From: Contact Centre (CRM) <contact@ribblevalley.gov.uk>
Sent: 08 January 2023 23:28
To: Planning
Subject: Planning Application Comments - 3/2022/1127 FS-Case-476967141

Planning Application Reference No.: 3/2022/1127

Address of Development: Overdale, York Lane, Langho BB6 8DT

Proposal: Variation of Condition 2 (Plans) of previous application 3/2021/0567

Ground Floor Plan

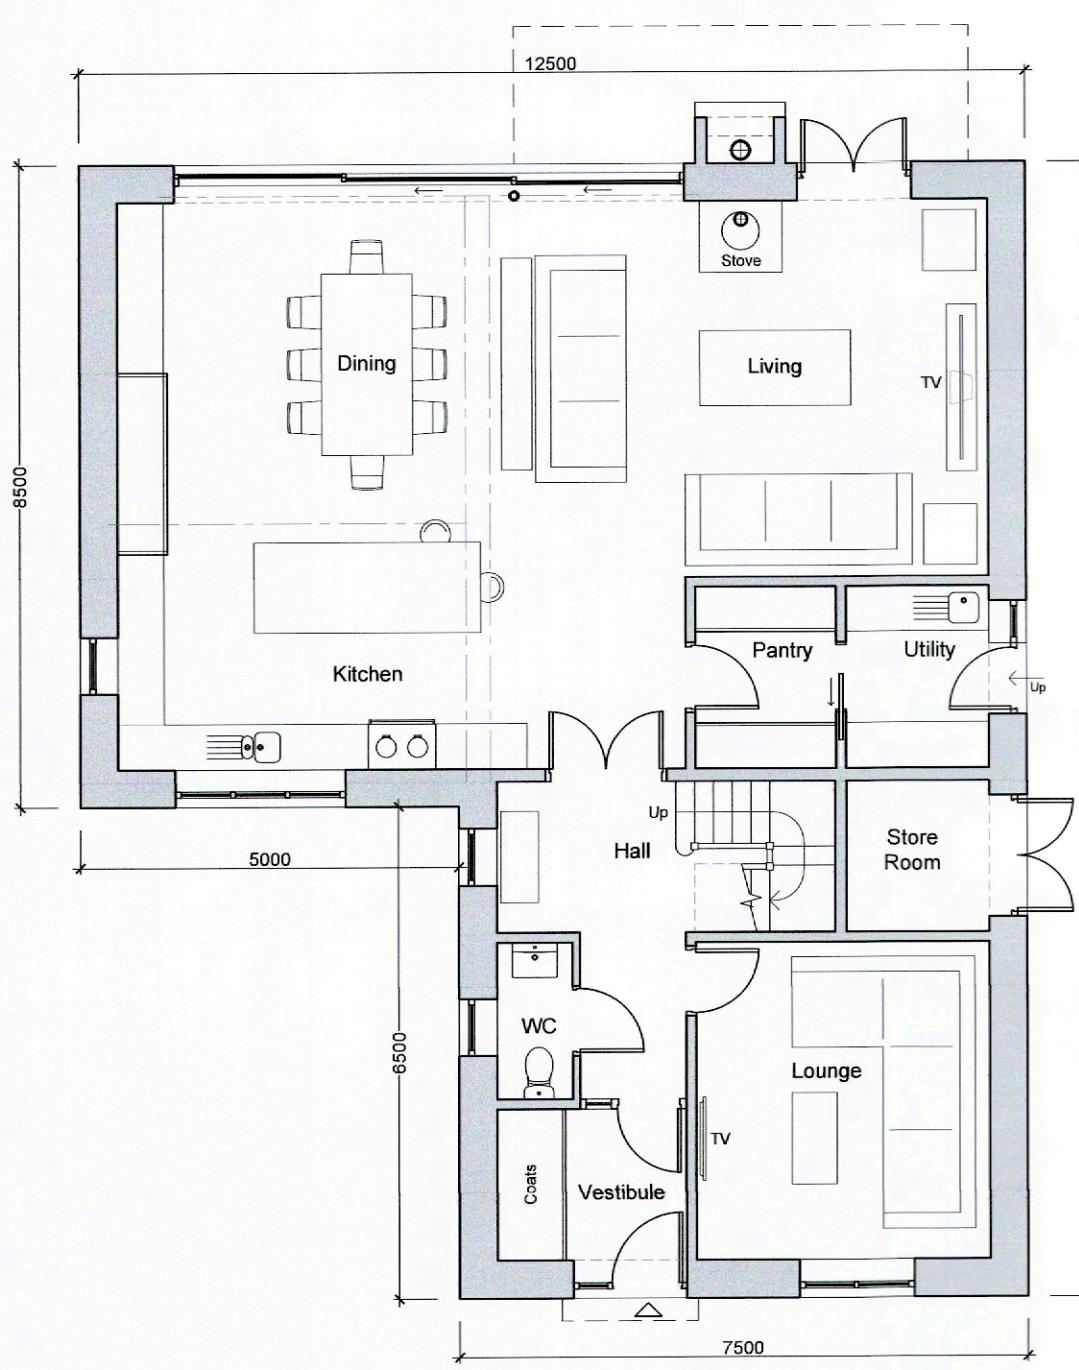
- Whilst the proposed property is a lower height compared to the previously approved plans, the proposed property location on the site is significantly further forward compared to what has been approved. This will have a significant impact [REDACTED] hence my strong objection. The previously approved plans were very considerate to minimise loss of light (and loss of views) whereas these plans are not.

[REDACTED] Whilst previous planning was approved, the revised plans are much further forward (nearer to York Lane) compared to what was approved.

Site Section C-C

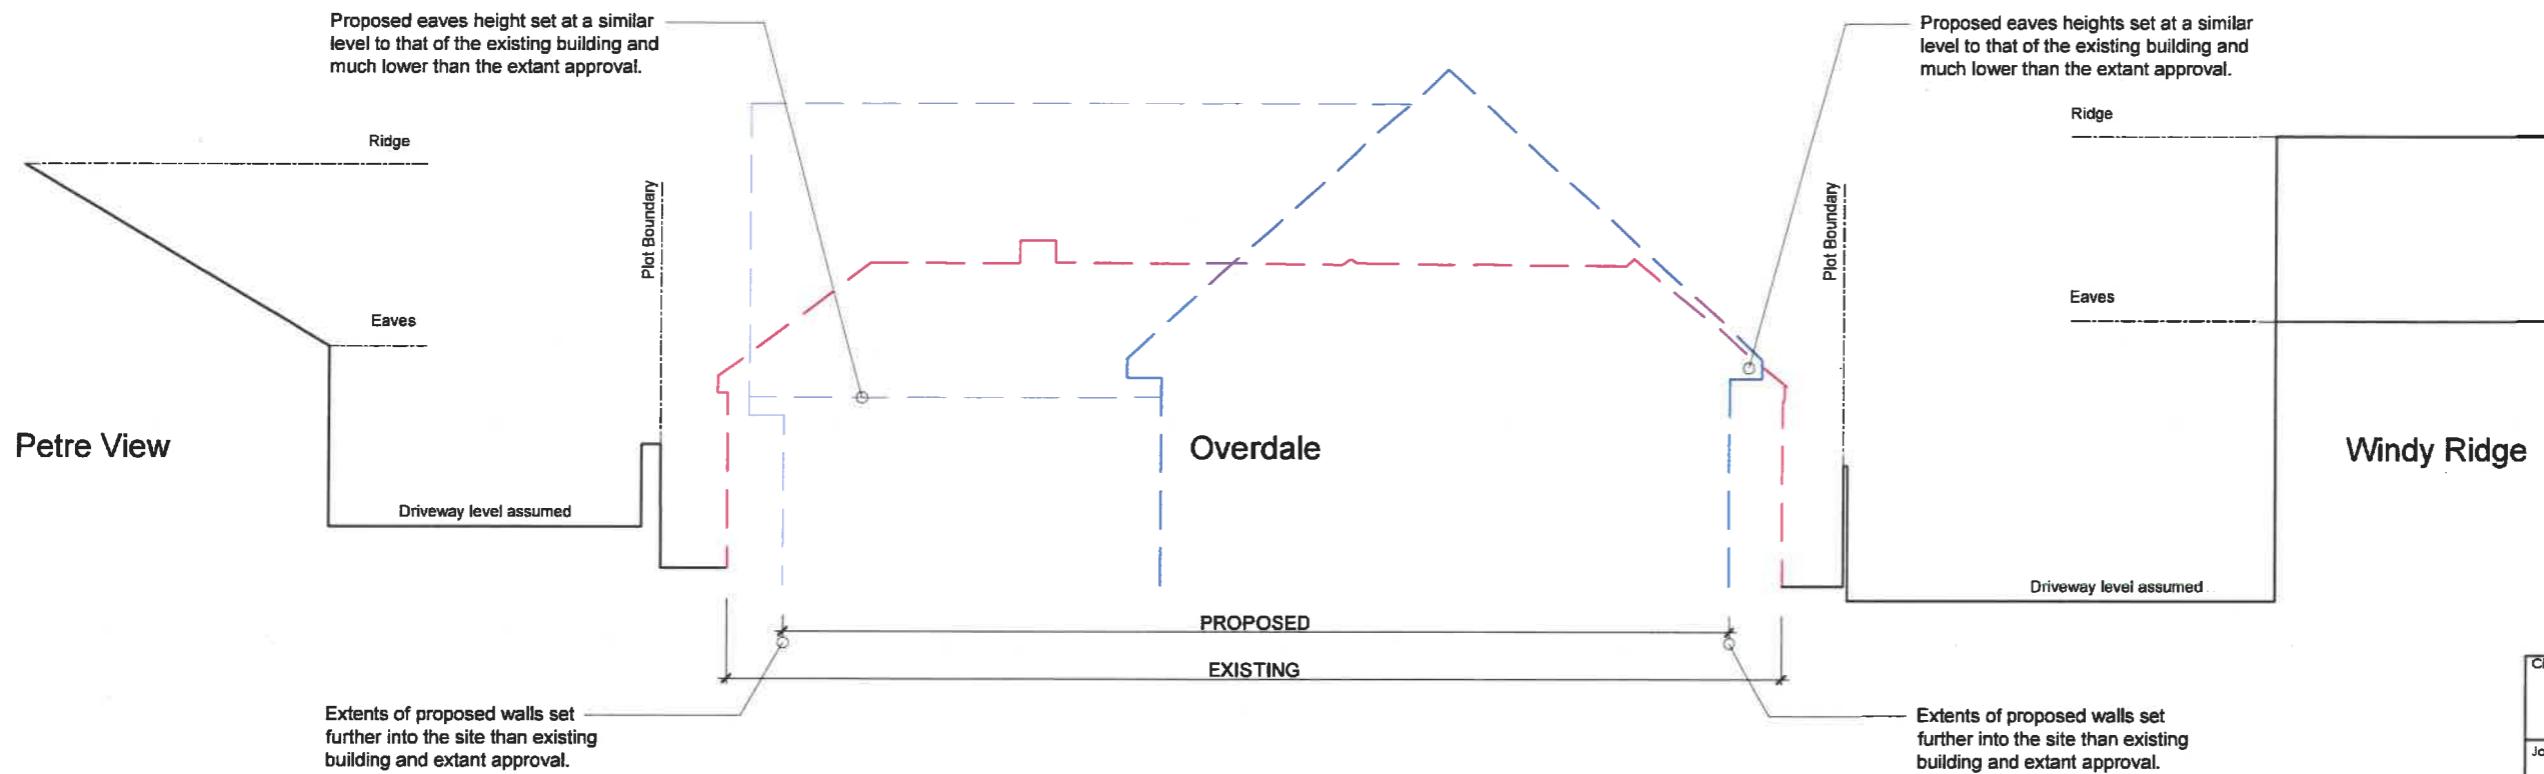
- Comparing the height of the proposed property to neighbouring Windy Ridge is irrelevant and misleading – Windy Ridge is not directly opposite a residential property and is of a significantly smaller footprint.

- Comparing the height of the proposed property to neighbouring Petre View is misleading. The footprint of Windy Ridge at that height is relatively small

- Also note that whilst there are some 1.5 and 2-storey properties adjacent to the proposed rebuild, all properties that are directly opposite to the row of terraced cottages are one-storey.
